SEEGER HOMES INC. - SALES OFFICE

SITE DEVELOPMENT PLANS  
LOT 3, APPALOOSA HIGHWAY 24 SUBDIVISION

SALES OFFICE  
GRADING AND EROSION  
CONTROL PLAN

SHEET NO:	GP-01
DATE:	09/28/18
PAGE NO:	1 OF 3

LOT 3, APPALOOSA HIGHWAY 24 SUBDIVISION FILING NO 1A

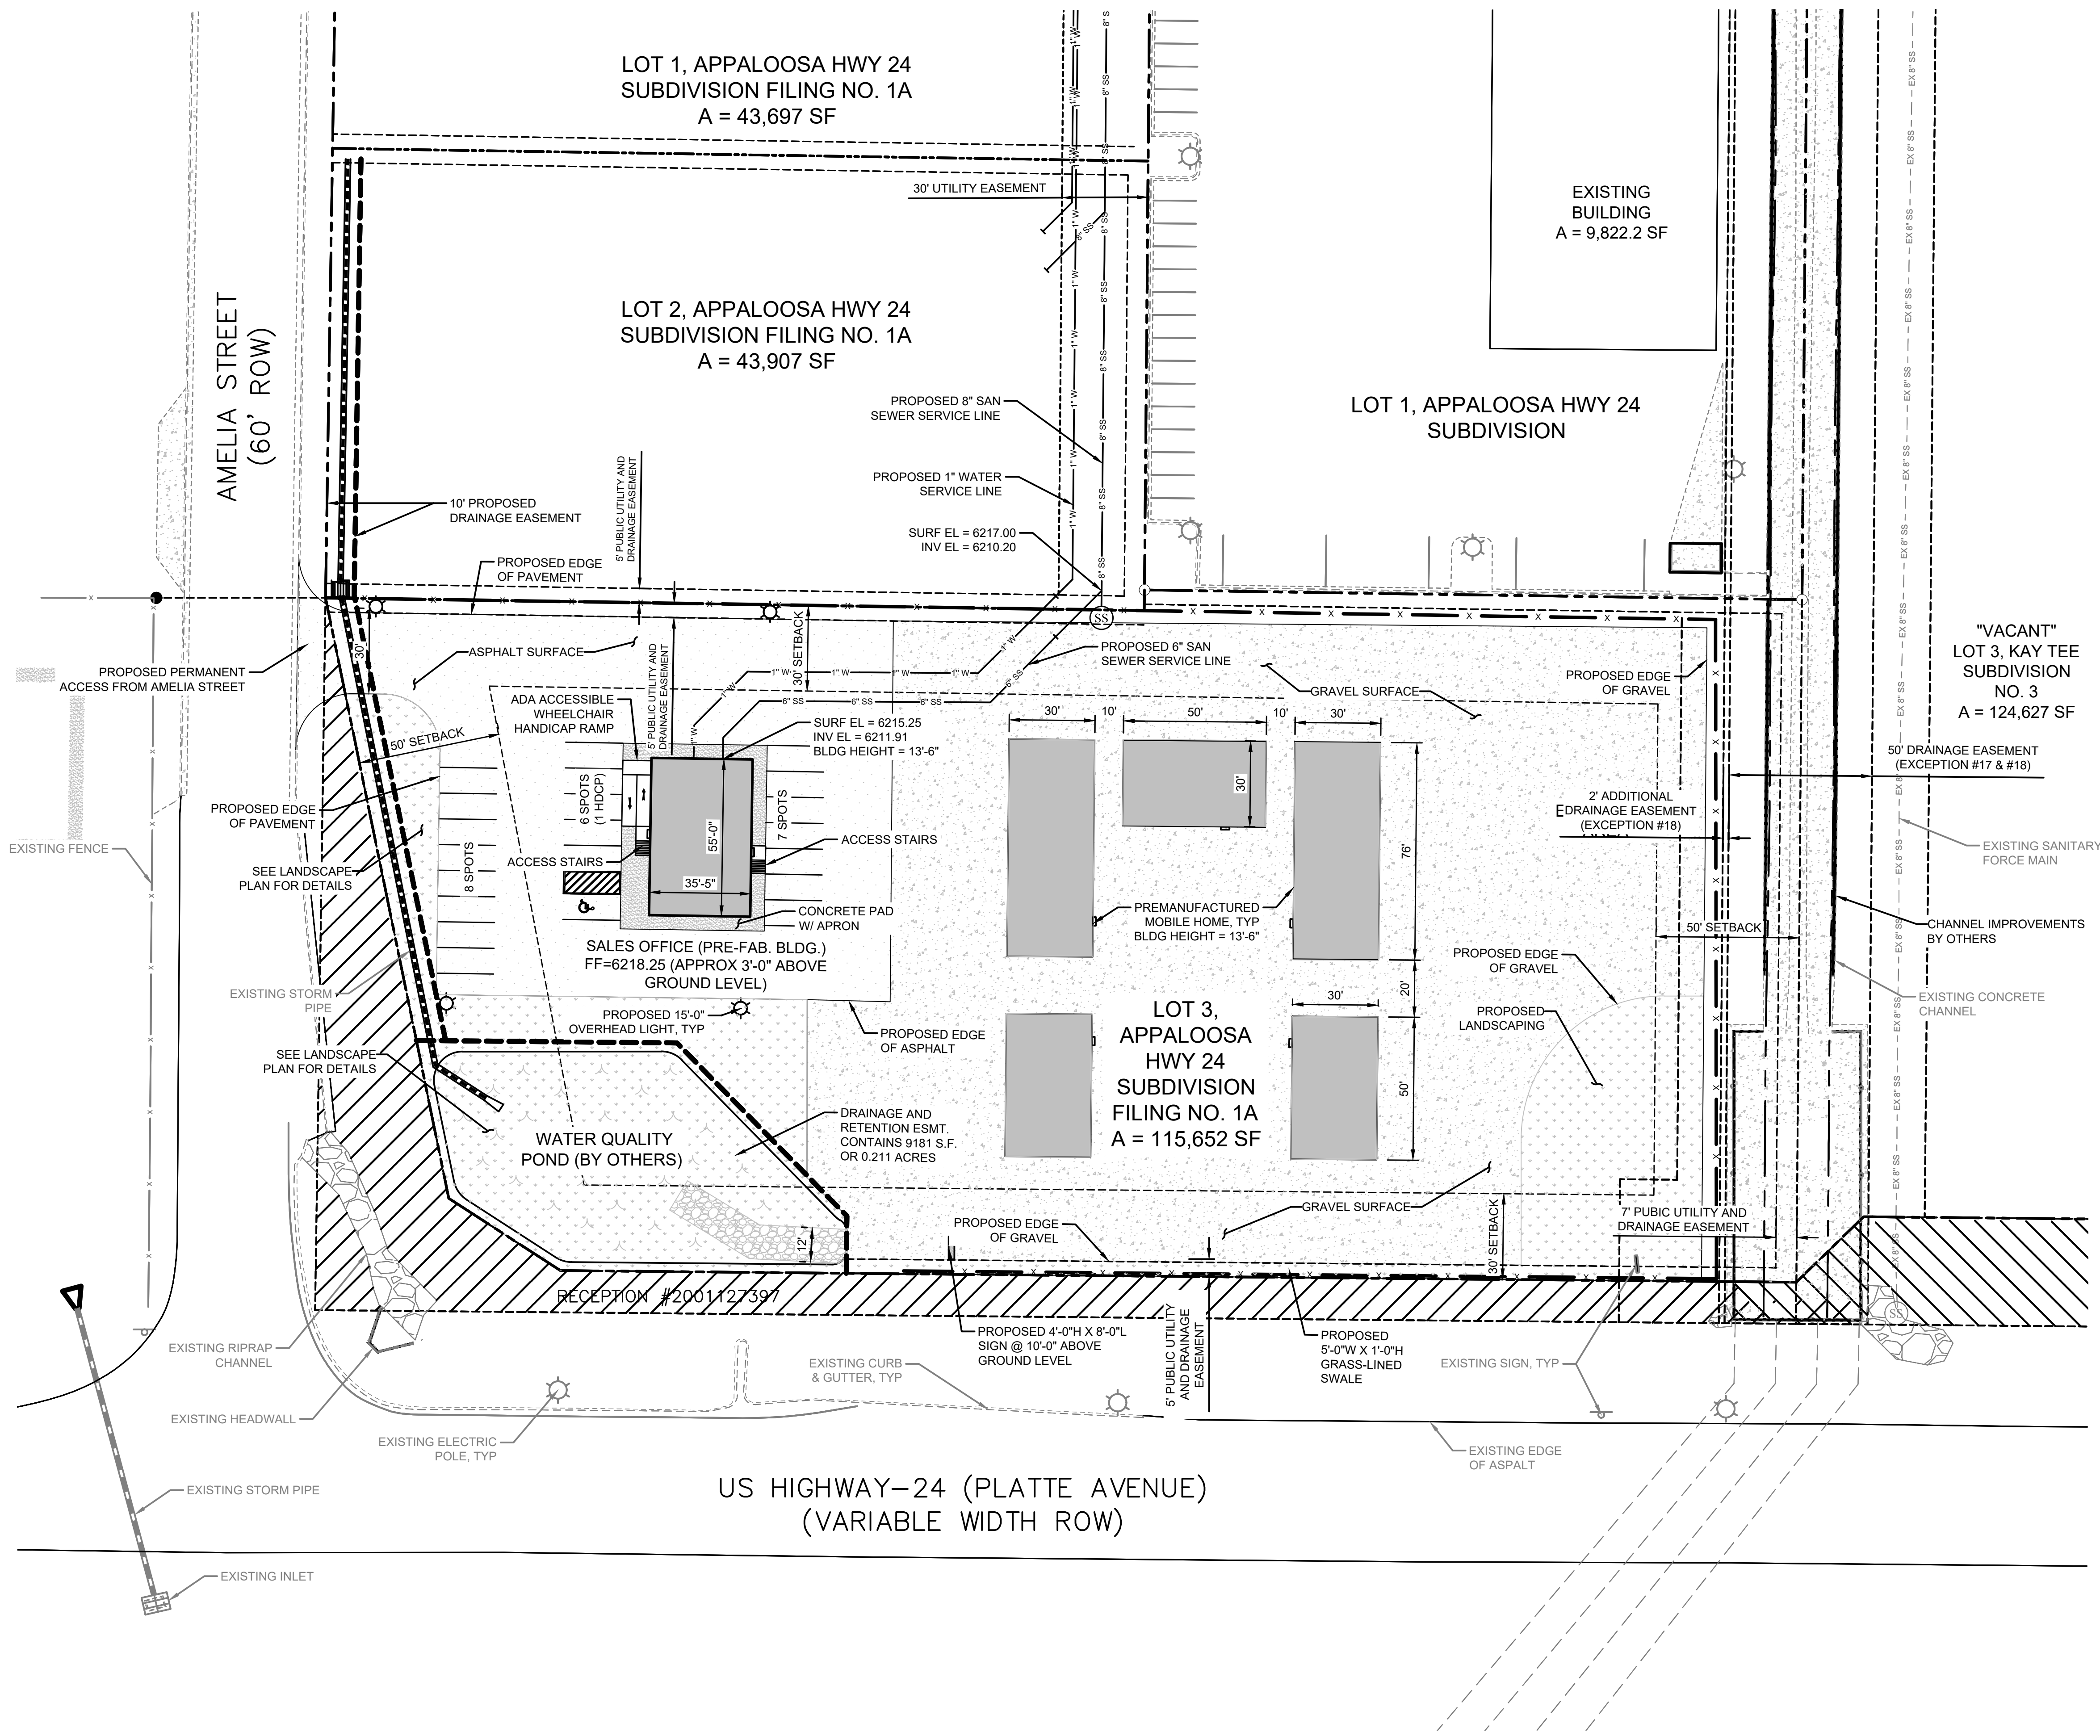
100% of the runoff from the site must go through the detention pond. It appears that the runoff from this corner will go into the concrete channel.

Be sure to include the names of those signing the plan

Filing No. 1A. Revise.

Identify where the FEMA 100-year floodplain is delineated. I cannot tell where it is delineated based on where the arrow is pointed.

Make sure that the detention pond is completely protected for the construction stormwater runoff.

Provide a note identifying why a sediment basin is not being used for the construction activity.
